SSD-10432 (Stone Ridge Quarry Project)

Corner of Italia Road and Hamburger Trail, Balickera NSW 2324

In response to the public exhibition of the Stone Ridge Quarry Project, Boral has preliminary concerns regarding the proposed entrance point to the Stone Ridge Quarry being directly opposite Boral's existing entrance point as per the figure below.

Client	AUSTRALIAN RESOURCE DEVELOPMENT GROUP
Project	ARDG / ERS / BORAL - ITALIA ROAD ACCESS ARRANGEMENTS
Title	STRATEGIC CONCEPT DESIGN ALTERNATE OPTION 03
Original Size	A3
Drawing No:	22-19467-SK110
Rev:	A

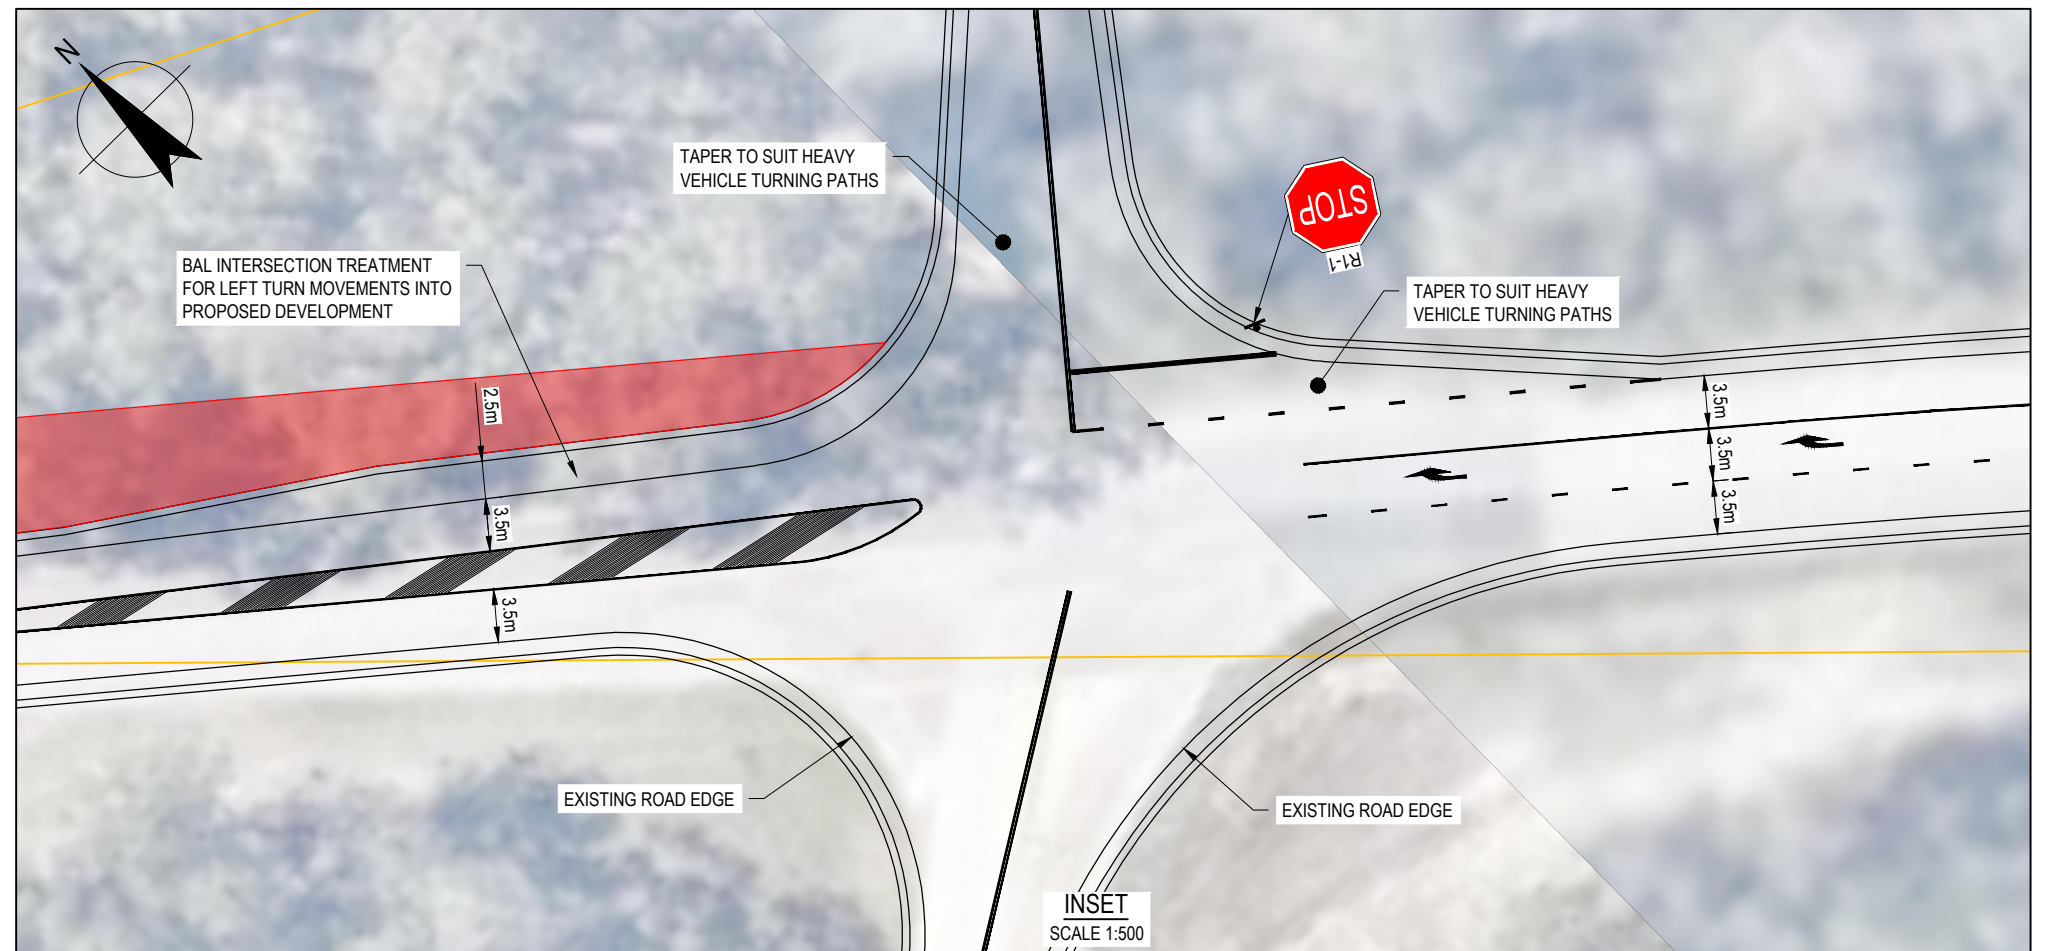
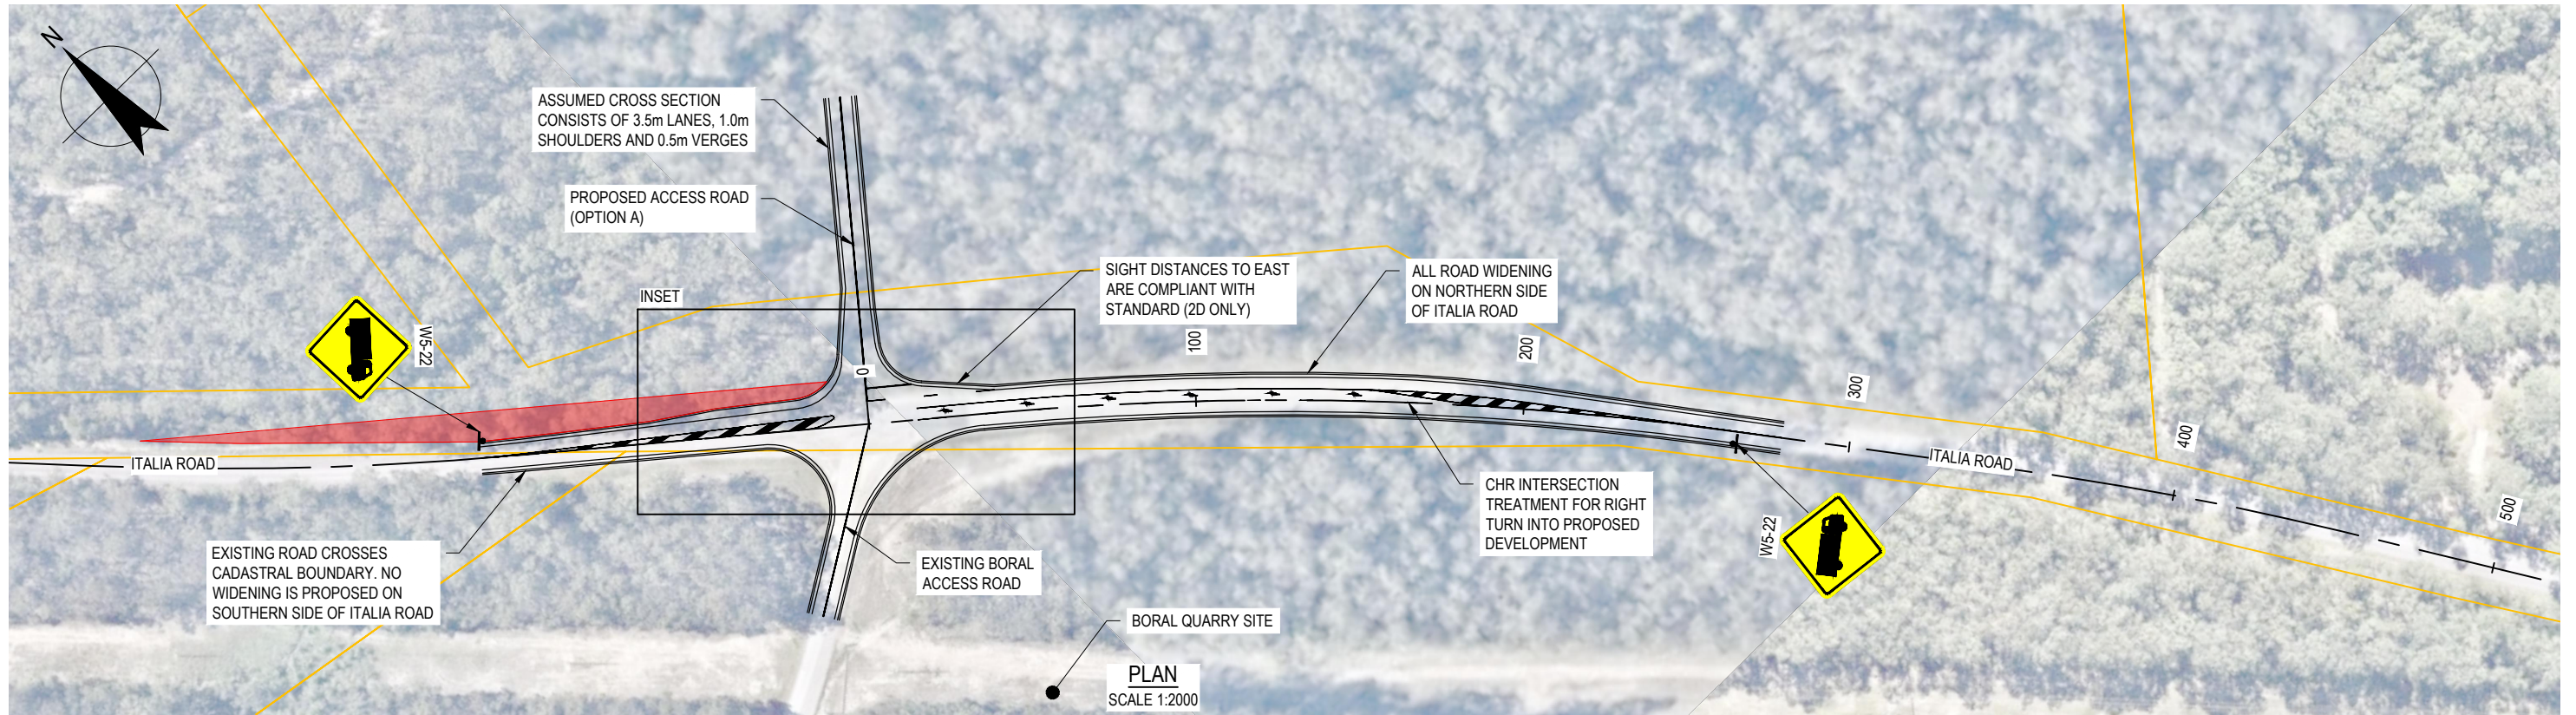
Boral requests that Australian Resource Development Group (ARDG) provide an updated Transport Impact Assessment to address the following matters:

- Sight distance assessment be undertaken to the left and right along Italia Road in accordance with relevant Austroads guidelines.
- An assessment of the potential impacts of the Boral / Stone Ridge Quarry intersection on Italia Road based on the vehicle movements proposed under both SSD applications and future growth.
